Angmering Parish Council
The Corner House
The Square
Angmering
West Sussex
BN16 4EA

Our Ref: A/15/18/A

Various illuminated & non illuminated advertisements on various elevations & internally illuminated pylon sign.

Caffyns Audi Worthing Roundstone By-Pass Road Angmering

Sign G - Pylon

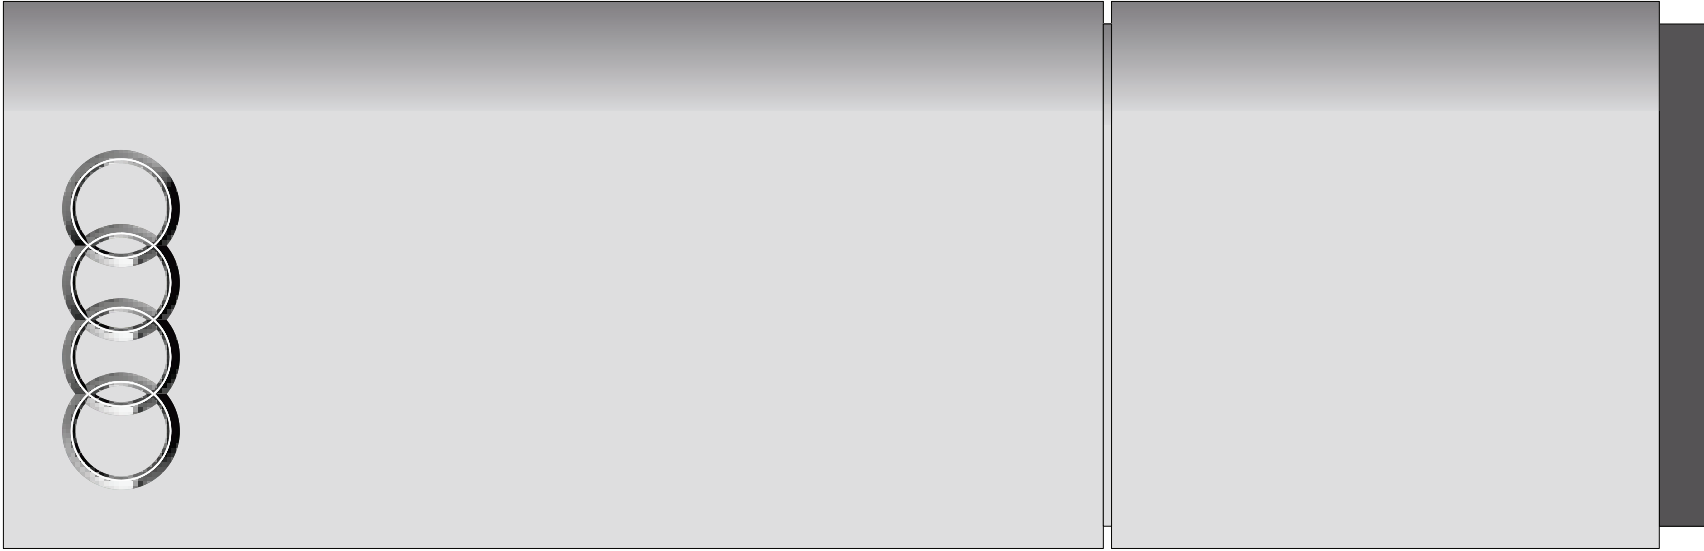
Subject to the illuminated signs being of the appropriate brightness; being sensitive to the location / residents. They should not cause an unsafe distraction to drivers.
